From: Amanda Scholes on behalf of Planning.Responses
Sent: 01 June 2020 08:47
To: Planning Scanning
Subject: FW: Y/22/20/DOC - land east of North End Road, Yapton, BN18 0AG

From: David Spring <David.Spring@arun.gov.uk>
Sent: 31 May 2020 18:14
To: Planning.Responses <Planning.Responses@arun.gov.uk>
Subject: FW: Y/22/20/DOC - land east of North End Road, Yapton, BN18 0AG

Figure 1 Trial Hole Plan

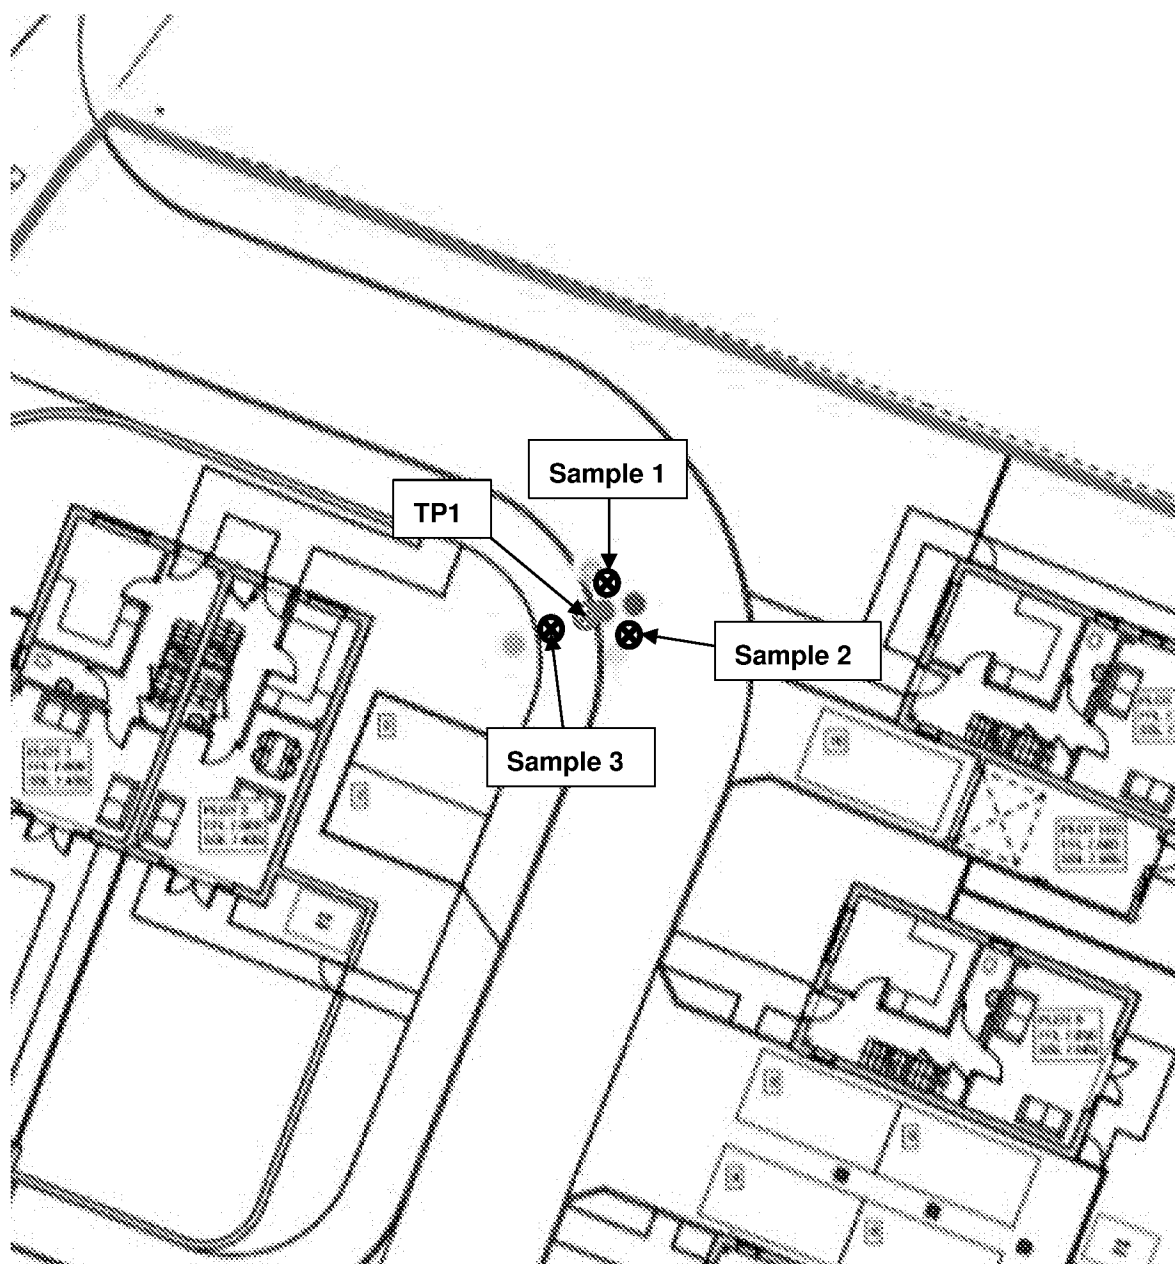
The e-mail provided states that validation tests for asbestos from samples taken around trial pit Red were conducted; is this in reference to the four trial pits Blue, Yellow, Green and Pink or has additional investigation been conducted? Forgive the confusion but the report states that the four trial pits were not sampled and no further sampling was undertaken at trial pit Red. Copies of any additional sampling results should please be provided. Samples 1, 2 and 3 were recovered from around trial pit Red by Crayfern / Soils Limited as this was seen as an omission from the HES report. These samples were tested for asbestos and none was encountered, essentially validating the extent of asbestos contamination encountered in trial pit Red. Results of these tests are also included in the attached letter report.

Furthermore, the location of the trail pits is in proximity to an area of soft landscaping associated with Plot 2, however no investigation of this area has been undertaken.

Crayfern recovered 3 No. samples (Sample 1, 2 and 3 as shown on Figure 1 in the attached letter) from around trial pit RED / original TP1 from depths corresponding with those where the asbestos containing soils were encountered within TP1/Red. DETS tested the samples and the results showed that no asbestos was present in the samples.

HES excavated trial pit Pink as part of their investigation into the extent of the asbestos impacted soil, no asbestos tiles were observed, neither was any similar Made Ground-like material, only clean, natural looking material. Crayfern / Soils Limited then excavated Sample 3 (see Figure 1 in attached letter report) which was tested for asbestos. No asbestos was detected confirming that the impacted soil did not extend towards the soft landscaped area.

Site report showing location and photos of test pits.

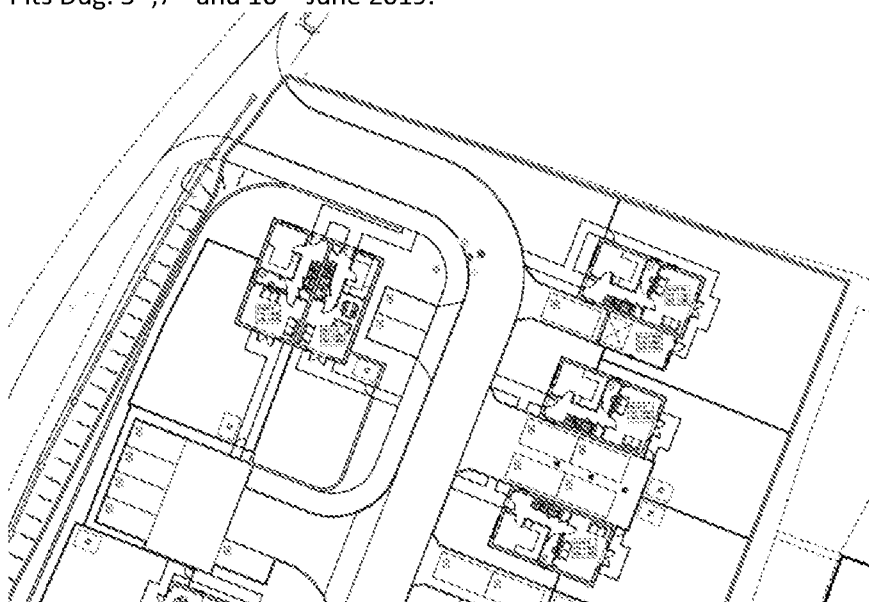
It is understood that the single sample obtained from trial pit Red did not return a positive result for asbestos and that the trial pit location has been excavated and covered by hardstanding. Please may the applicant confirm the extent of the excavated area as this has not been addressed in the submissions provided to date.
